Report of the Head of Planning, Sport and Green Spaces

Address 37 NEW ROAD HILLINGDON

Development: Erection of a single storey rear extension, which would extend beyond the rear wall of the original house by 5 metres, for which the maximum height would be 3 metres, and for which the height of the eaves would be 2.8 metres

LBH Ref Nos: **29296/APP/2014/3228**

PROPOSED GROUND FLOOR

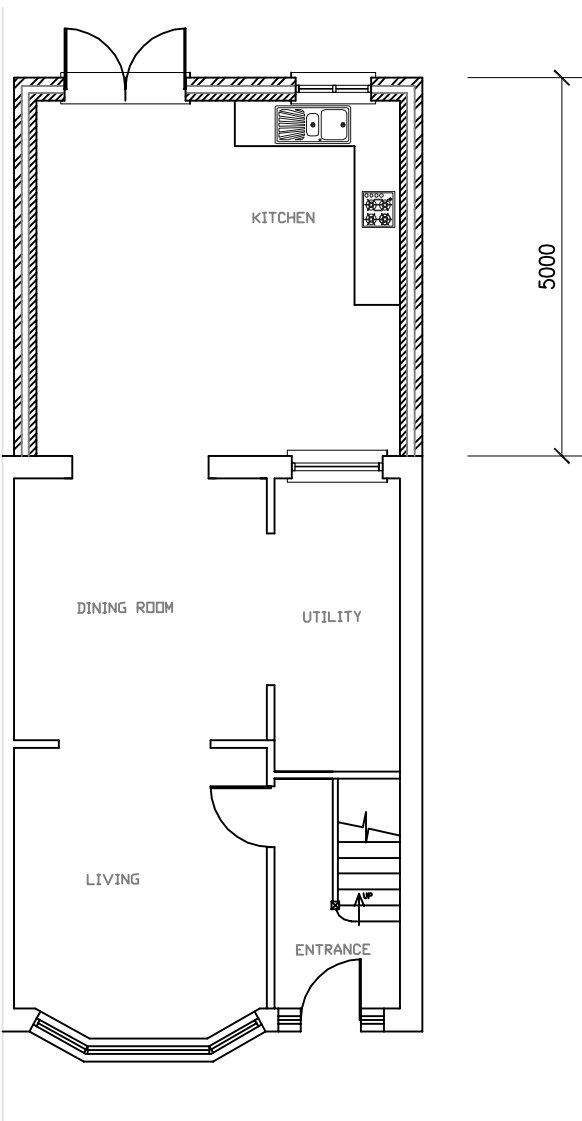
Where proposed extensions would exceed 3.6 metres in overall depth (including existing extensions) from the original rear wall of the dwelling, the effect on the quality and amount of natural daylight, sunlight and outlook available to the neighbouring properties is considered unacceptable.

Although both adjacent properties at numbers 35 and 41 New Road have been extended to the rear by way of single storey rear extensions (of depth around 3m and 3.5m) it is still considered that the proposed extension with a depth of 5m and height of 3m would have a significantly detrimental impact on the amenities of their occupiers. As such the proposal would result in a significant loss of daylight, outlook and an increased sense of enclosure for the occupants of these neighbouring dwellings. The proposal would be contrary to Policies BE20, BE21 and BE24 of the Hillingdon Local Plan: Part Two - Saved UDP Policies (November 2012).
